**KIRKLEES METROPOLITAN COUNCIL
INVESTMENT & REGENERATION SERVICE**

Reference No:	2023/62/92740/W
Site Address:	12, Inner Hey, Marsden, Huddersfield, HD7 6EL
Description:	Raise roof height to provide additional accommodation (within a Conservation Area)
Recommending Officer:	Laura Yeadon

DECISION – REFUSED

Officer Report

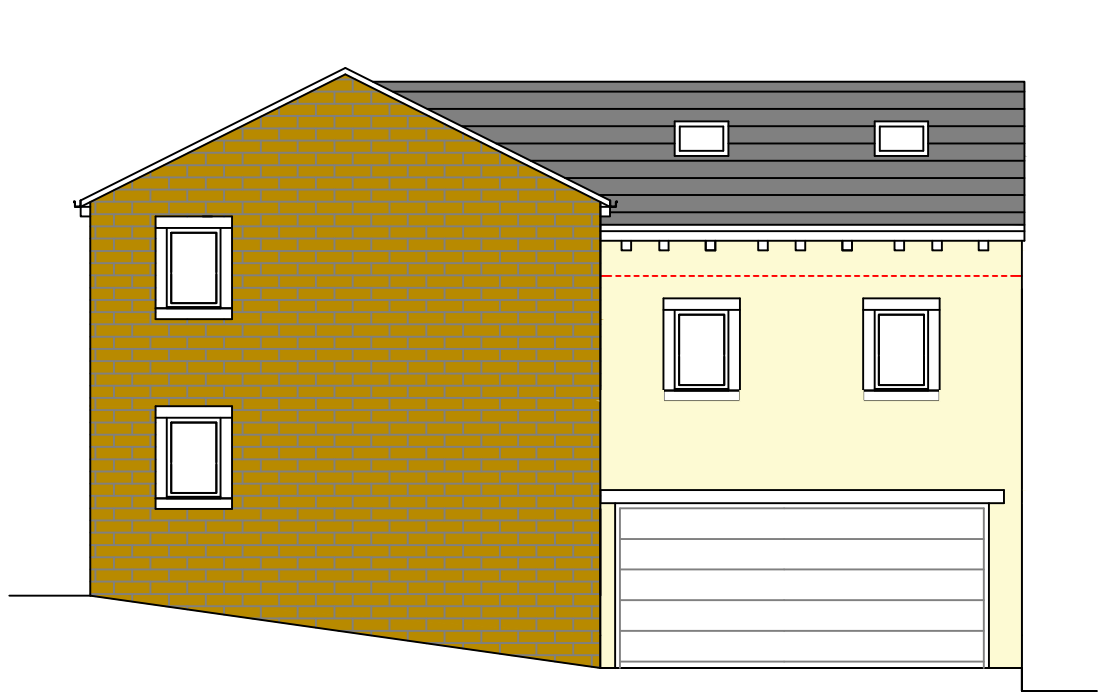
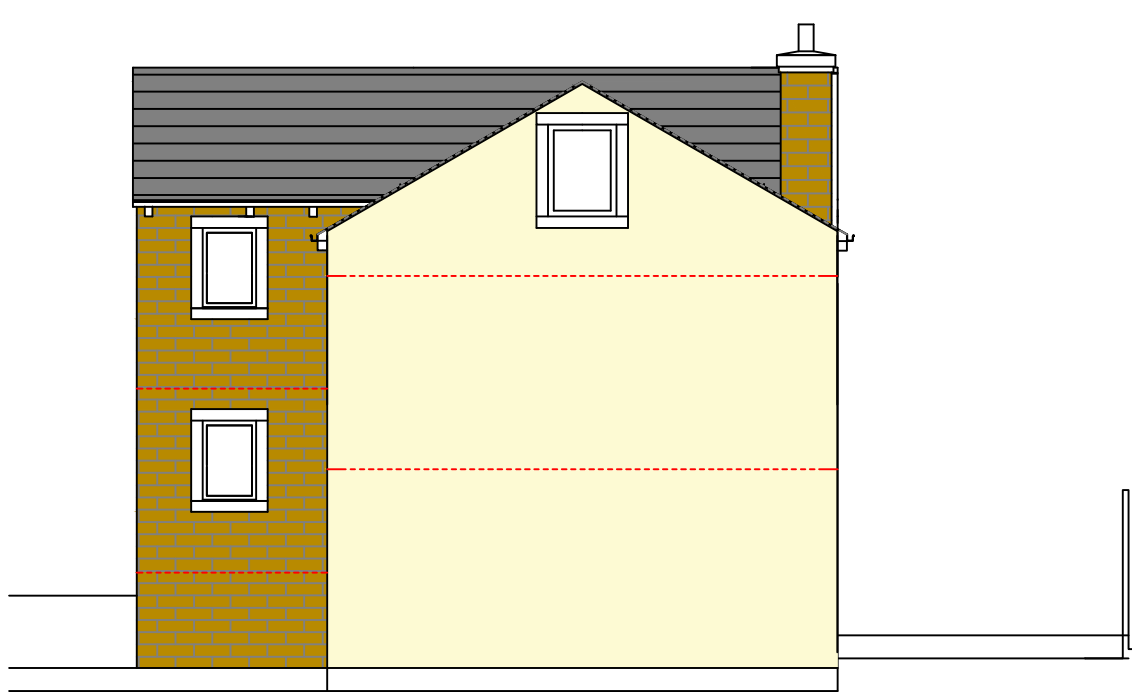
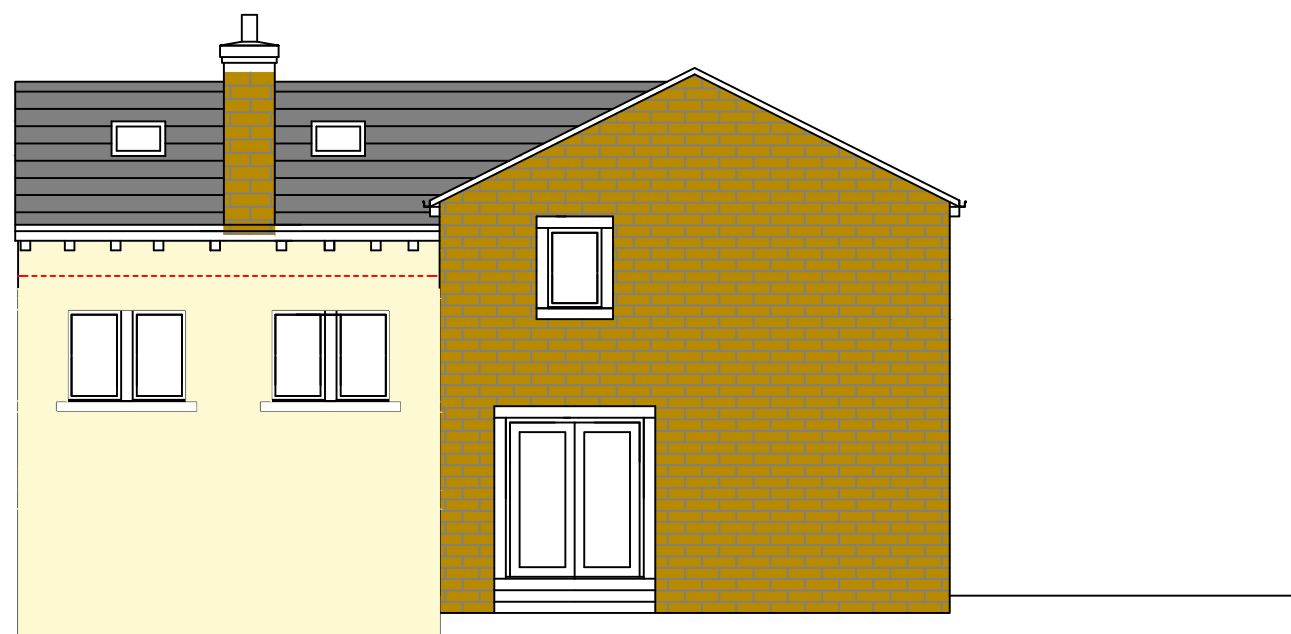
It is considered that in this instance, whilst the proposal has been reduced from its previously refused scheme, to raise the roof of the rear section of the property would have a harmful effect on the significance of the Conservation Area as the larger expanded massing of render would not preserve or enhance the character of the area contrary to Section 72(1) of the Planning (Listed Building and Conservation Areas) Act 1990. The rear section of the property would not be subservient to the host property and by adding an additional storey would not follow the pattern of this hillside street which it would dominate due to the elevated position of the proposal / application site.

It is not considered that the proposal would form a sympathetic addition to the property and would alter the character of the building due to the expanse of walling above the windows being clearly visible. The eaves height of the existing building sits slightly above the lintels and to increase this to the rear section of the dwelling would not retain this characteristic. Whilst it is noted that the extension would be partially screened from Carrs Road, the extension would be openly visible from Inner Hey and from Manchester Road below.

The proposals, whilst a modest overall height increase of 0.6 metres, would not be in keeping with the scale, design and local character of the area and does

not follow the topography and is therefore considered to cause less than substantial harm to the significance of the Marsden Conservation Area.

In conclusion, the proposed extension would have a harmful effect on the significance of the Conservation Area as the larger expanded massing of render

would not preserve or enhance the character of the area. The rear section of the property would not be subservient to the host property and by adding an additional storey would not follow the pattern of this hillside street which it would dominate. It is not considered that the proposal would be a sympathetic addition to the property and would alter the character of the building contrary to Section 72(1) of the Planning (Listed Building and Conservation Areas) Act 1990, Policy 24 and LP35 of the Kirklees Local Plan, Key Design Principles 1 and 2 of the House Extensions and Alterations SDP and Chapter 12 and 16 of the National Planning Policy Framework.

PROPOSED SECTION

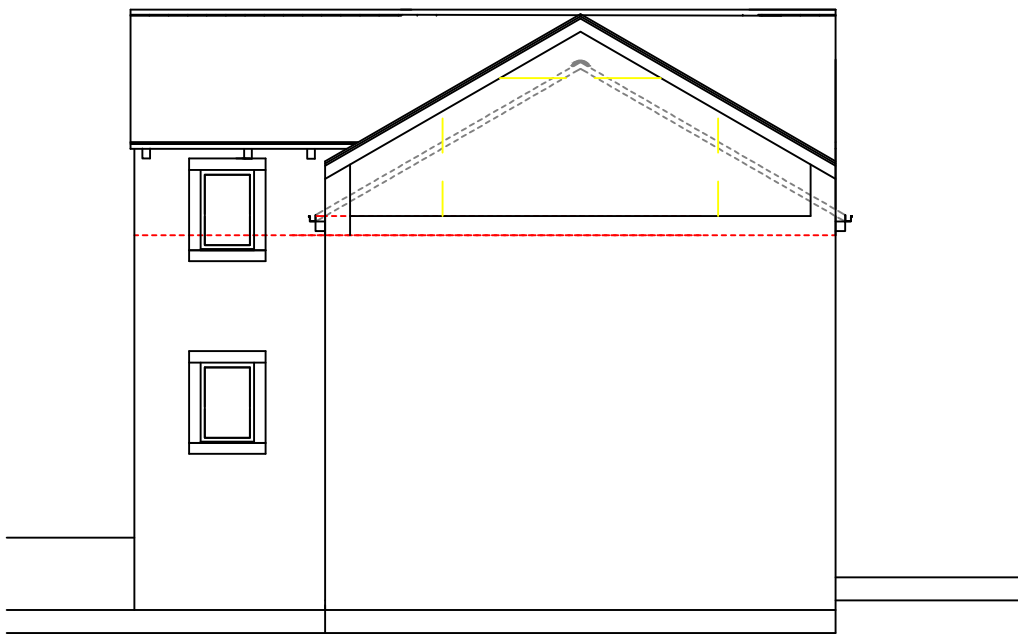
The existing eaves and ridge height of the rear section is 5.0 metres and 7.2 metres respectively and it is proposed that the eaves would be raised to 5.6 metres and the ridge would be raised to 7.8 metres. The ridge height would sit below the existing ridge on the main body of the property by 0.2 metres and the eaves would sit 0.4 metres below the existing. It is proposed that the construction materials would match the existing and it is also proposed that roof lights would be inserted into the north and south side elevations and a window in the second floor gable end (west elevation).

PROPOSED SECOND FLOOR PLAN

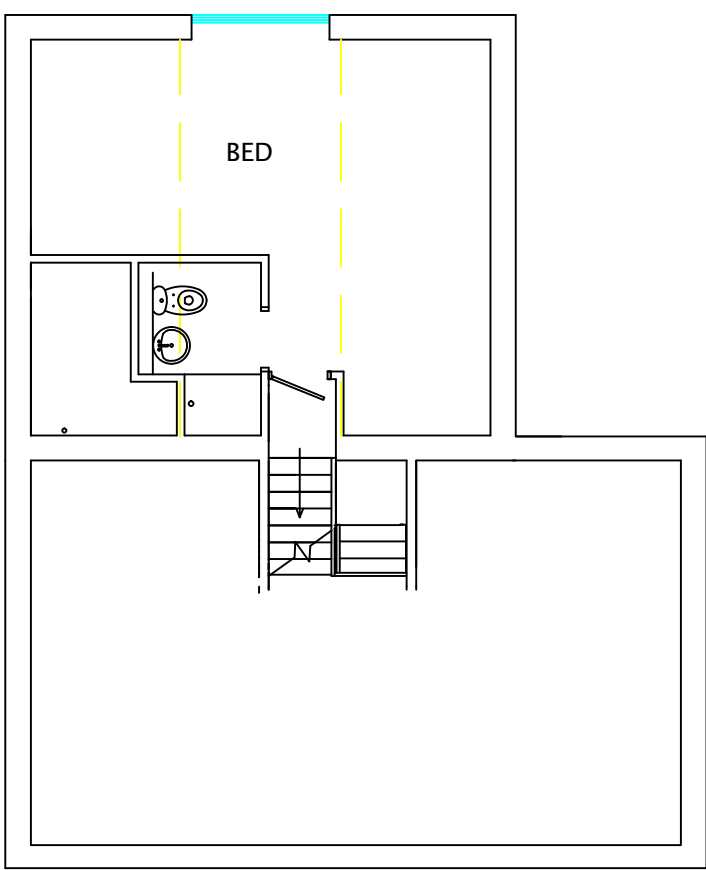
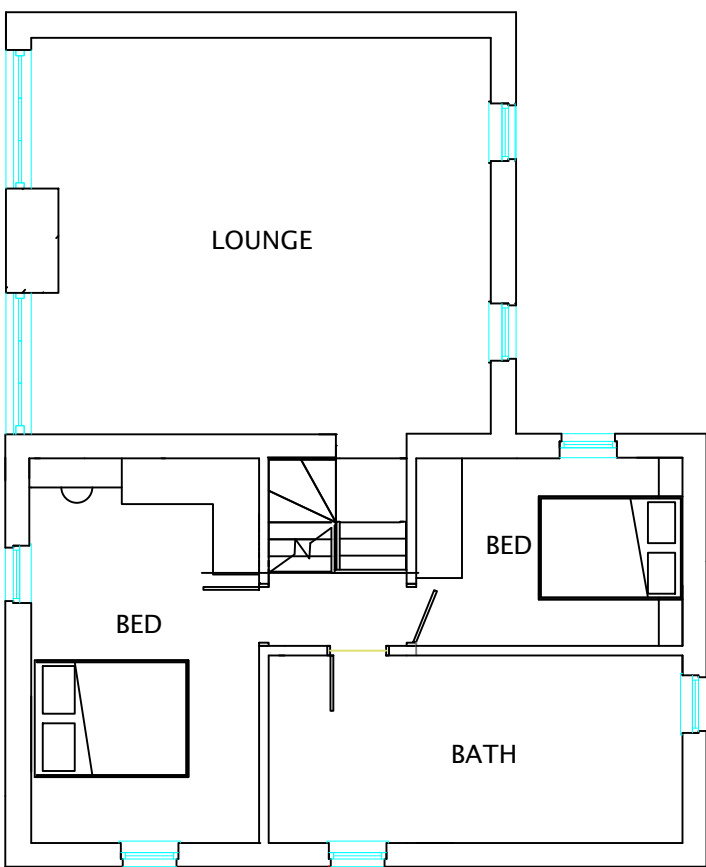
The submitted plans indicate that the garage provision at ground floor would be retained with the first floor reconfigured to provide a lounge, 2 no. bedrooms and a bathroom at first floor with a bedroom and en-suite within the second floor. As such, the number of bedrooms would not be increased as a result of the works.

This application seeks to overcome this previous reason for refusal by retaining the garage provision as existing and enlarging the existing bedrooms and bathroom without increasing the number of bedrooms. The existing garage provision falls short of the recommended 6m x 6m to provide accommodation for 2 no. vehicles and the space to the front of the garage is limited. However, given that the three bedrooms would be retained alongside the garage provision, it would be unreasonable for the LPA to require additional parking in this case. As such, it is considered that the previous reason for refusal has been overcome by the reconfigured internal accommodation.
